Our Ref: N0241372-CLTR-01A

Project: Class 2 Mixed-use Project

Address: 37 Archer Street
Chatswood NSW 2067

Appendix A – 37 Archer Street Comments Register

GROUND FLOOR STORMWATER PLAN
SCALE 1 : 100

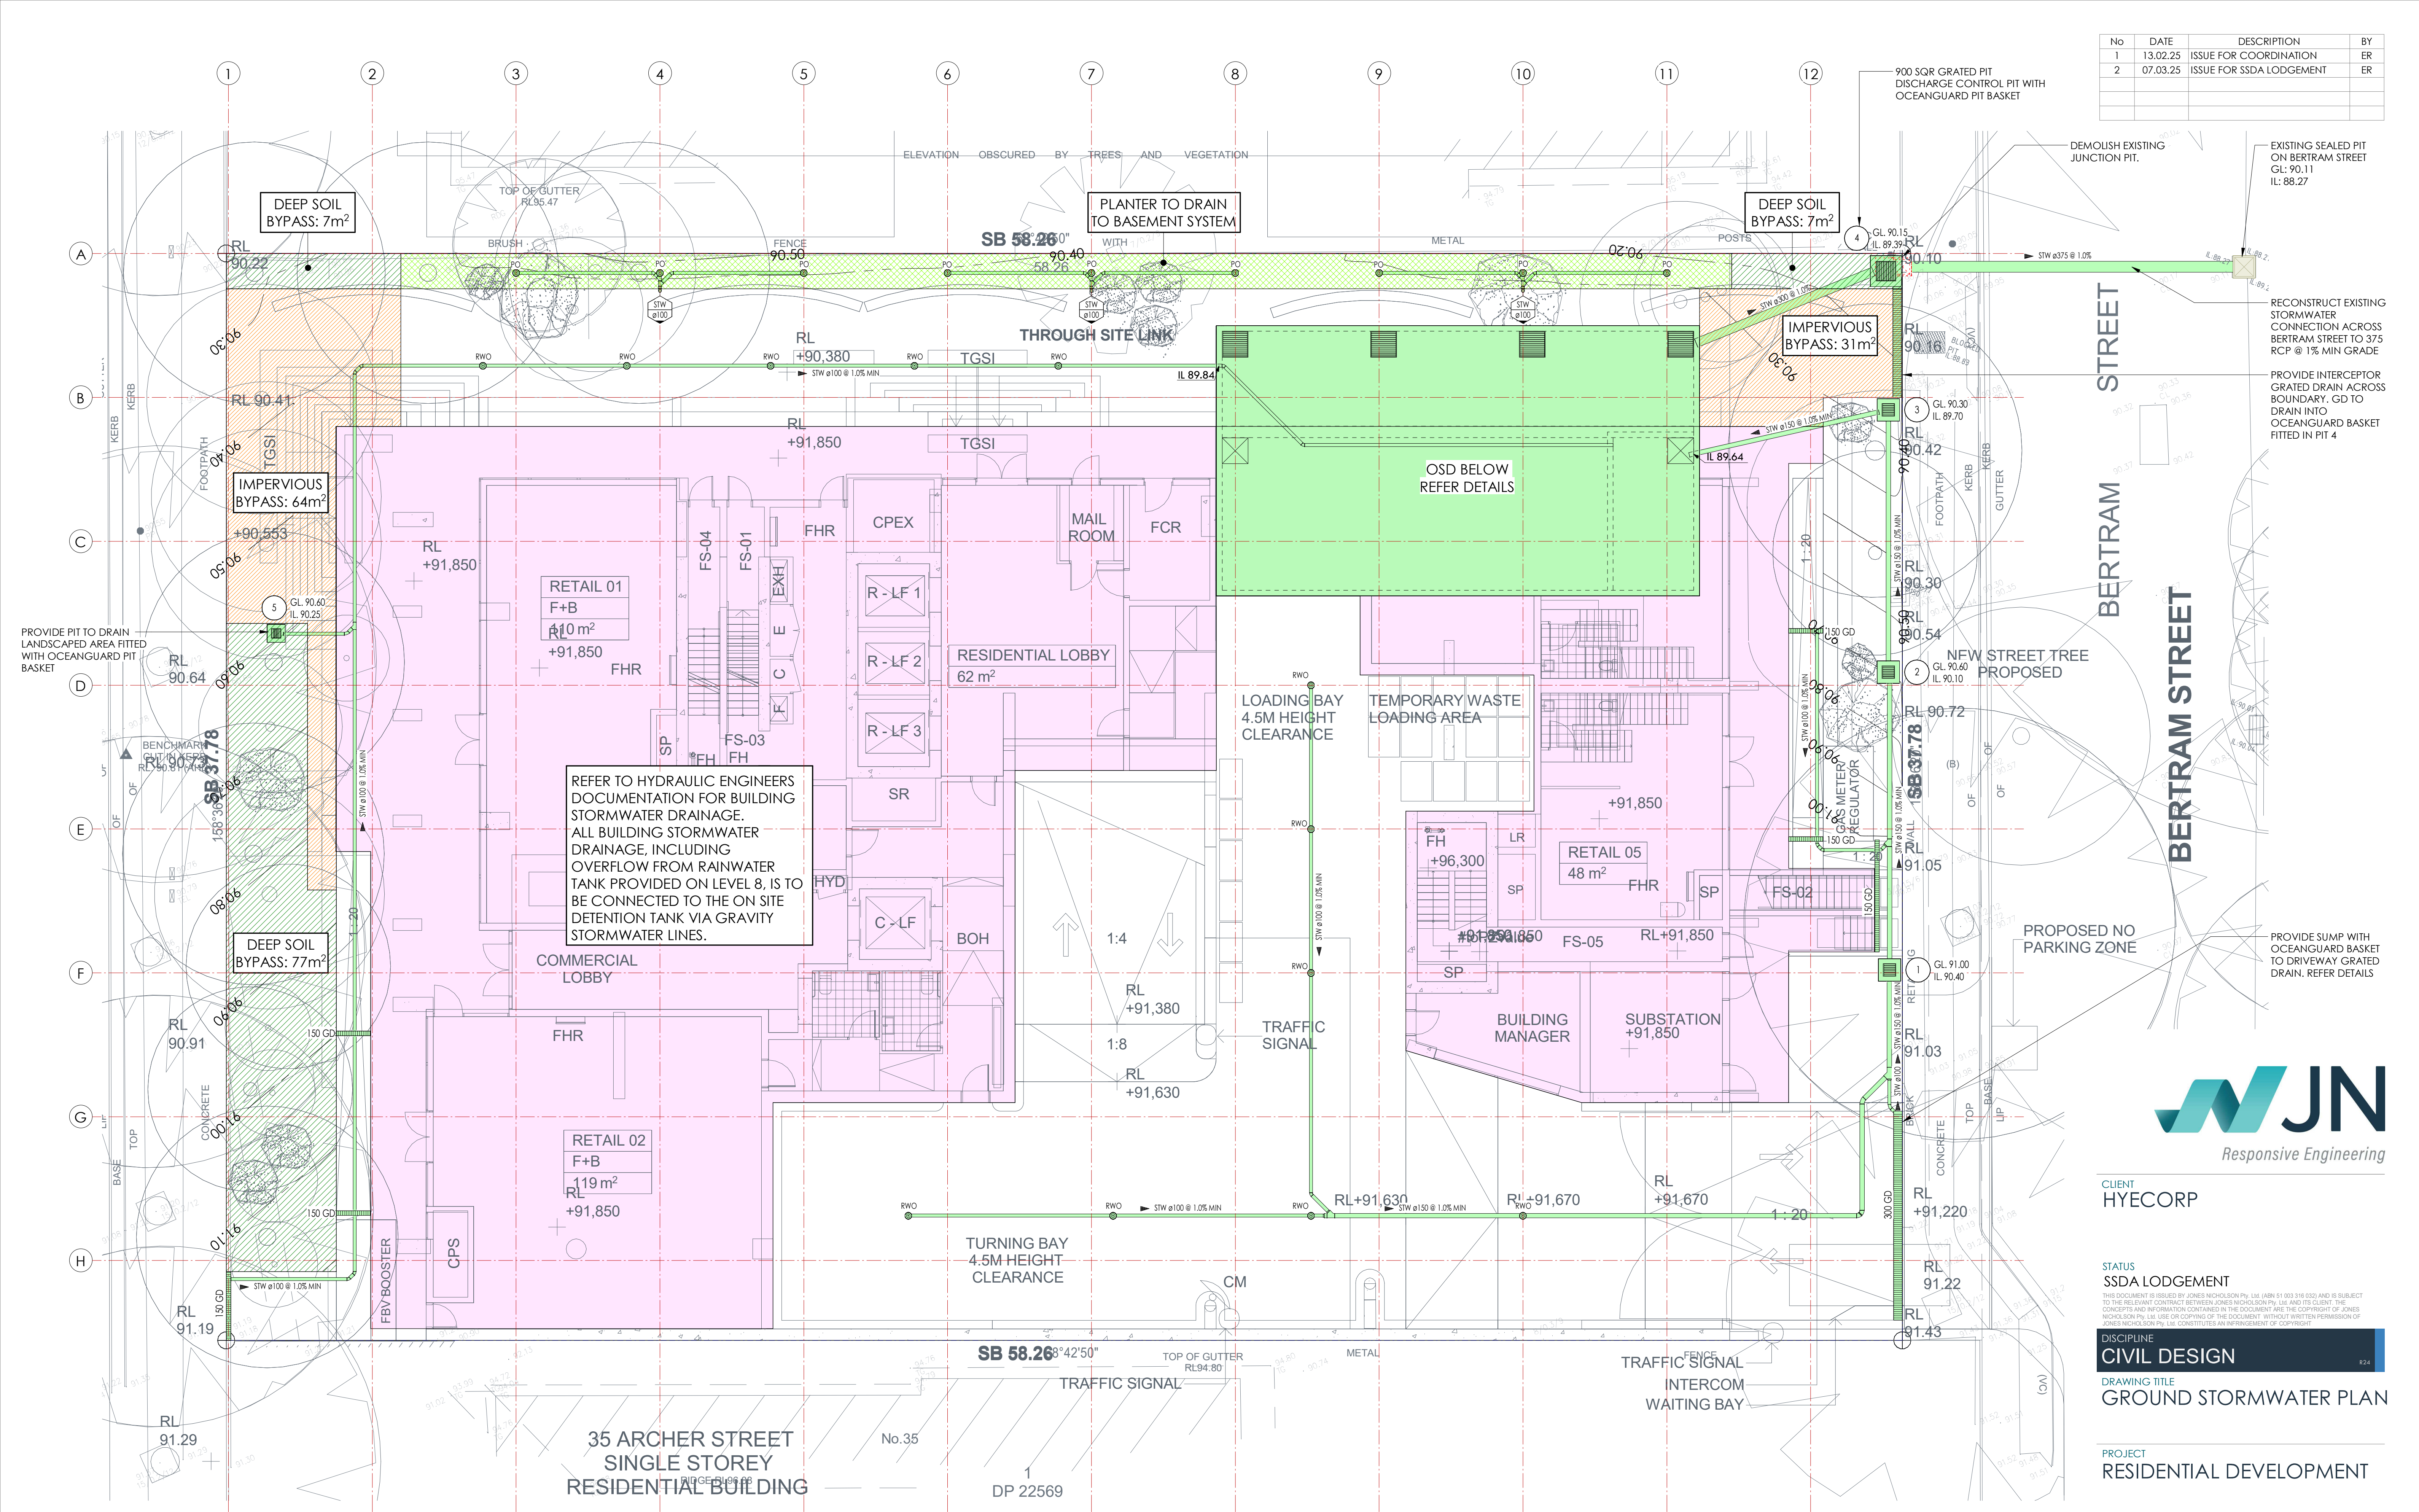
5	Section d) Stormwater Management of	Willoughby City Council	Access points to the OSD tank are generally location on one site only. To allow for cross-ventilation, safe	Access grates are located in the northern corners of the OSD tank, as well as over the outlet.	Drawing N0241372 C054 and C200.

Attachment 1 – Council Submission		<p>access to the tank and to minimise the need to enter the tank, access points should be located at all corners of the tank, and as a minimum over the outlet and the diagonally opposite corner. To ensure that access is available at all times, particularly for emergency maintenance, all access points to the tank need to be located in common areas and not in tenancies. The plans are not clear that this is achieved. The architectural plans should be amended to show the location of the OSD tank and all access points to the tank.</p>	<p>Access grates cannot be placed in the south-east and south-west corners of the OSD tank as these points are located within retail tenancies.</p> <p>All proposed access points to the OSD are in common areas and not in tenancies.</p> <p>Civil plans show updated OSD access points for coordination with architects.</p>	
6	Section d) Stormwater Management of Attachment 1 – Council Submission	Willoughby City Council	<p>As the tank is not located in a position where flows in excess of the capacity of the pipe network can drain to the OSD tank, the internal pipe network needs to be designed to cater for the flow from the 1%AEP event.</p>	<p>Internal pipe network has been designed and sized for flow from the 1% AEP storm event.</p>	Drawing N0241372 C200.
